KITTITAS COUNTY

MEMORANDUM

TO: Jeff Watson, Community Development Services
FROM: Christina Wollman, Planner II *W*
DATE: October 9, 2012
SUBJECT: Plum Creek SG-12-00006

The Public Works Department has reviewed the Request for Parcel Segregation Application. In order to ensure that it meets current Kittitas County Road Standards, the applicant needs to provide the following prior to final approval:

**K.C.C. 17.08.327
INTERVENING OWNERSHIP
PARCEL SEGREGATION
EXHIBIT FOR
PLUM CREEK
TIMBERLANDS, L.P.**

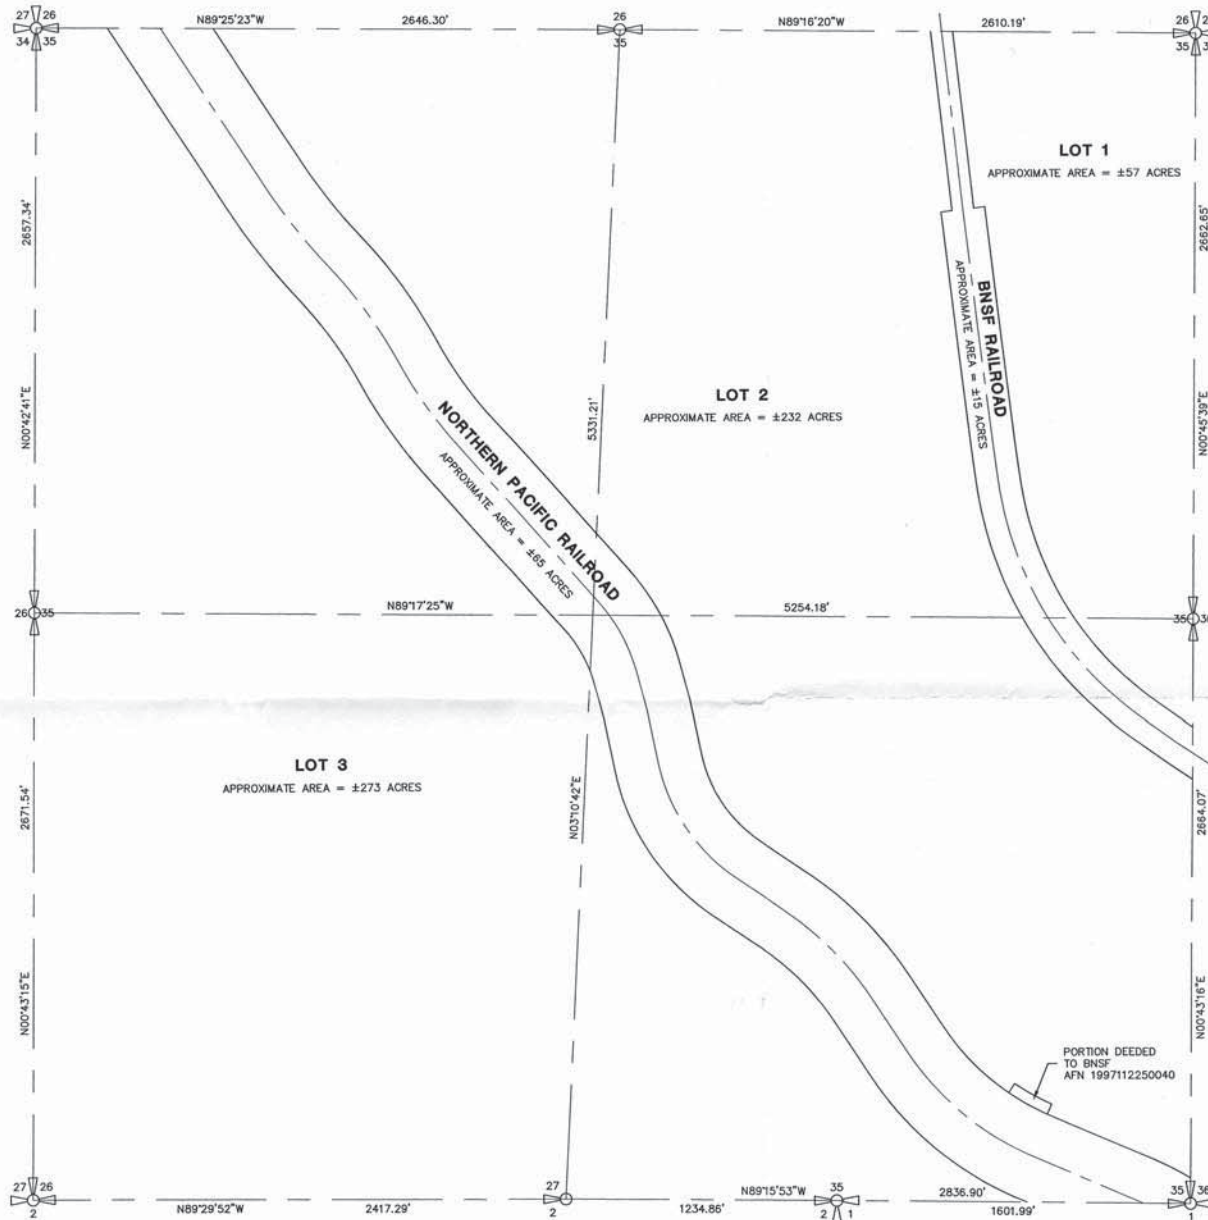
1. The proposed access with appropriate easement(s) shall be shown and shall conform to applicable Kittitas County Road Standards.
